Development Facilitation Team (DFT) – Review Comments

DRB Project No: PR-2018-1560 Date: 08/23/2023 Agenda Item: #9 Zone Atlas Page: E-20

Legal Description: Tract A-2 PLAT OF TRACTS A-1 & A-2 Hoffmantown Baptist Church Site

Application For: SD-2023-00156- Final Plat (DHO)

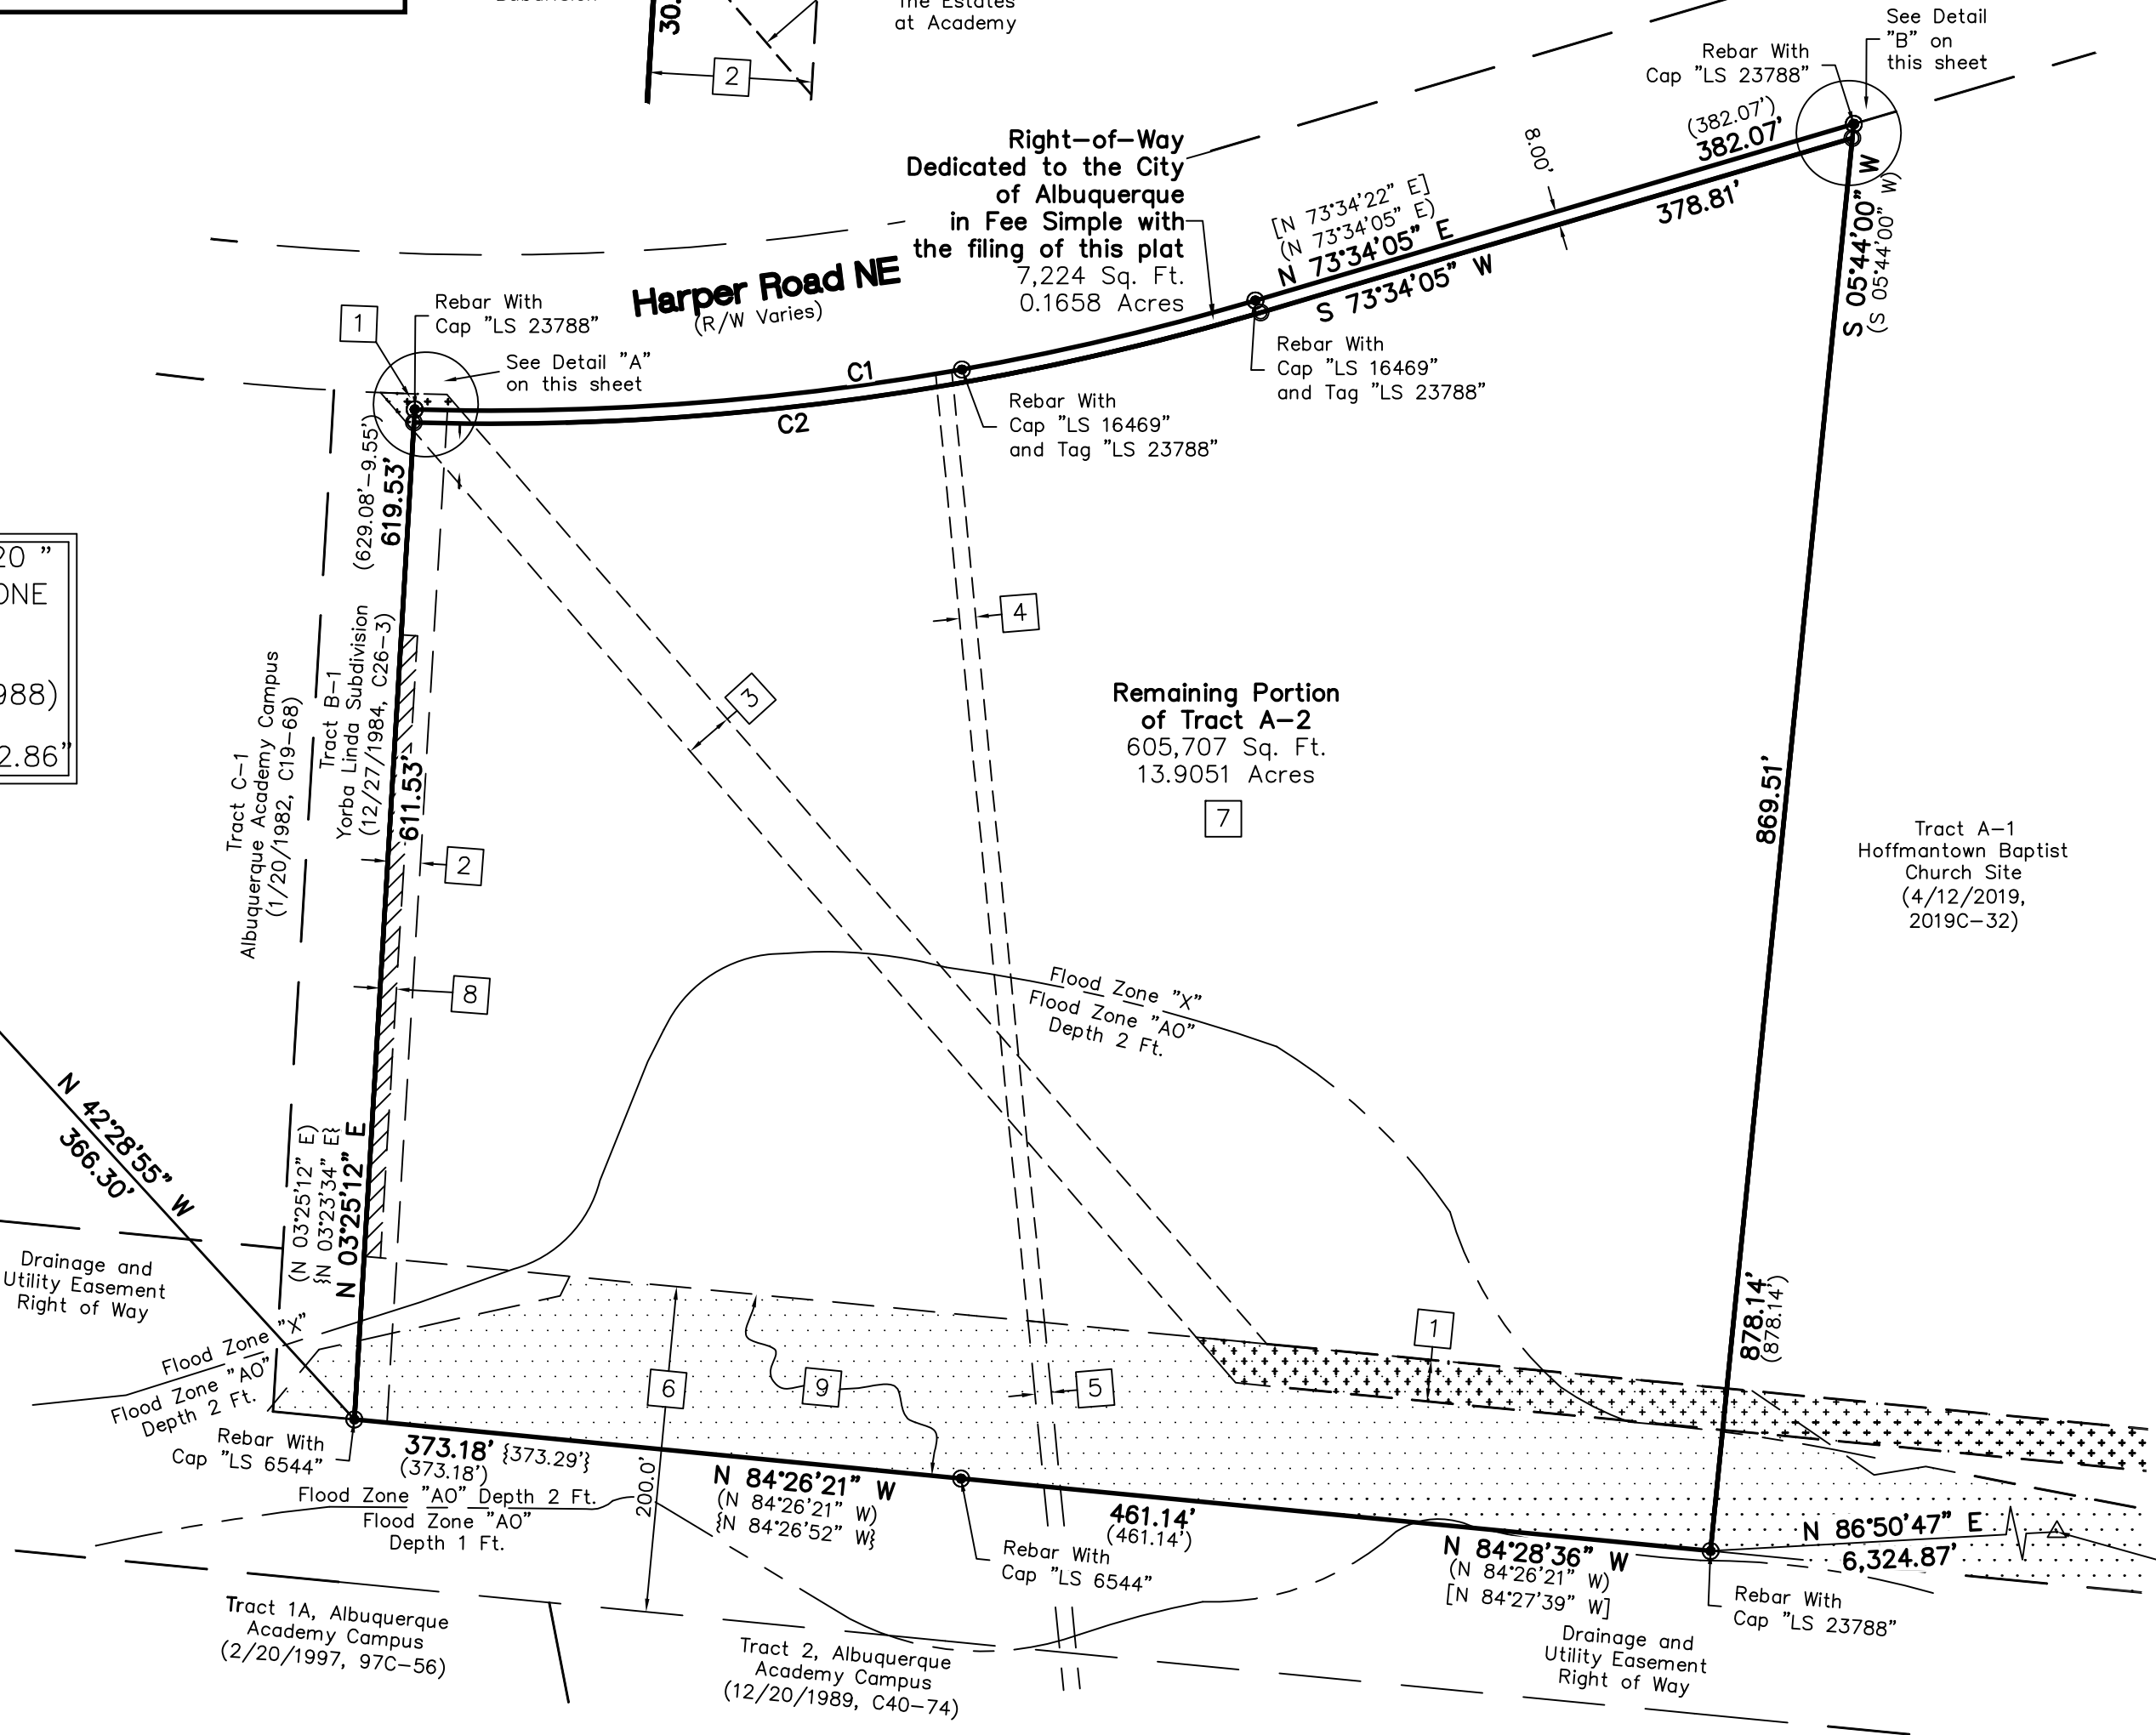
1. The plat states that Tract 13 has a subsurface easement and that the tract will be maintained by the Water Authority. Please clearly state that the easement is simply for public water and public sanitary sewer. The added note covers the uses. Please note the maintenance will be on the HOA and not the Authority.

2. Easement 12 needs to have a clear boundary. Also, there appears to be a missing portion at the NW corner of the site for the proposed sanitary sewer to access the existing manhole within the public right-of-way.

3. For note 15, when overlapping the sanitary sewer and water easements, please clearly note the specific use. We do not want drainage features such as rip-rap, storm drains, ponds etc... within an easement that is intended also for water and sanitary sewer.

4. Please note that the existing infrastructure must have an easement in place until construction is complete. If one will not be maintained with this plat, as discussed, a paper easement must be granted for the interim until construction is completed. That easement can then be vacated once the lines have been properly relocated and approved.

5. Easement 1 is shown to remain within public right-of-way at the NW corner of the platted area. Please clean this up and clarify the purpose of that portion.

6. Easement 5 needs to be cleaned up to provide a 20' corridor exclusive to the public waterline. Additionally, for lot 19, this may require an additional 5 ft of the corner to be included in tract 10. Maybe another potential option?

7. For the record, a note was discussed to be added to the plat stating which lots cannot be constructed on until the water and sanitary sewer line were to be relocated as well. Building permits shall not be issued on those lots until the work order is closed and the relocated lines accepted.
